# CITY OF ALBUQUERQUE

December 16, 2011

**Re: The Bosque Center, Grading and Drainage Plan  
Engineer's Stamp Dated 11-23-11 (D13/D009)**

C-100

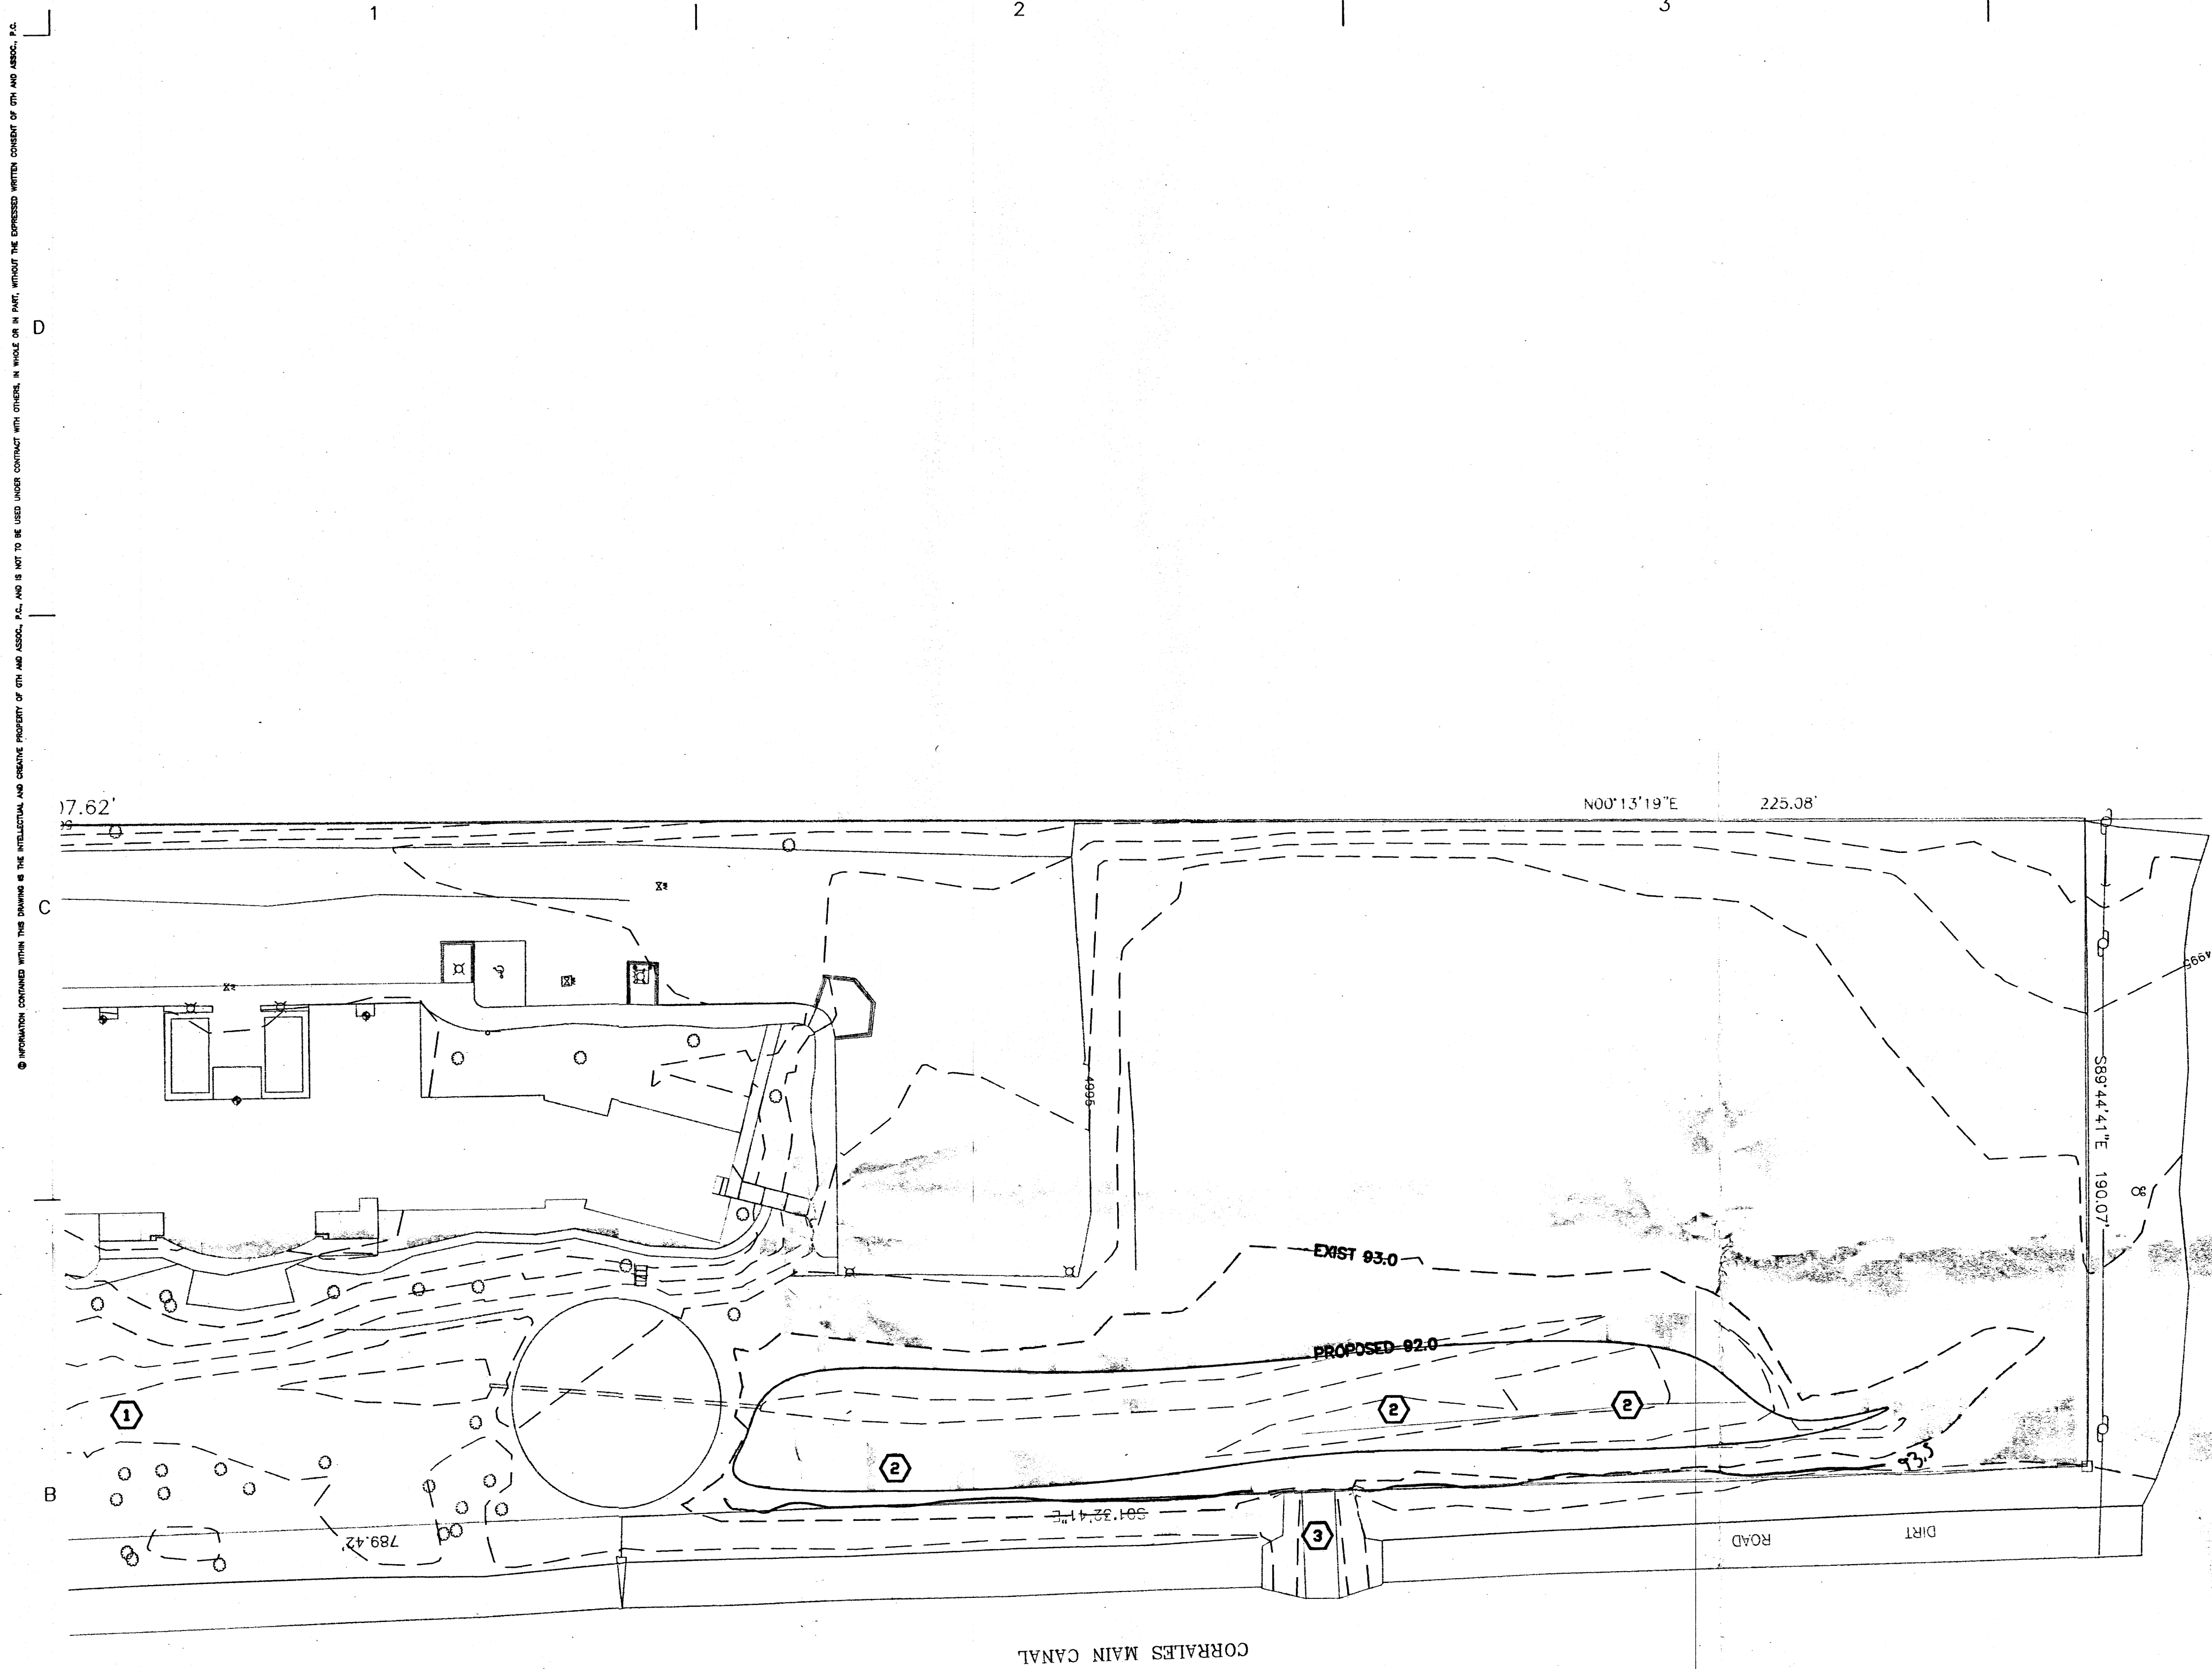
- AMAFCA approval is required.
- The plan appears to meet the sedimentation goals of the North Coors DMP; however, it should be stated.
- Provide the Volume Required, Volume Provided and WSE for each Water Harvesting Area on the Grading Plan. These values are part of the Certification.
- I couldn't find the Pond 2 routing in the AHYMO output. Please direct or provide.
- Please provide the AHYMO Summary Table.
- The Q Max numbers in the AHYMO output do not match the numbers in the Hydrology table.
- The Peak Discharge Rate from Water Harvesting Area 1 in the AHYMO is 1.19 CFS. The rating curve for these pipes shows 1.05 cfs at an elevation of 96.
- Seems a small berm is required on the east side of Water Harvesting Area 5 (not at spillway) to ensure the spillway is the low point.
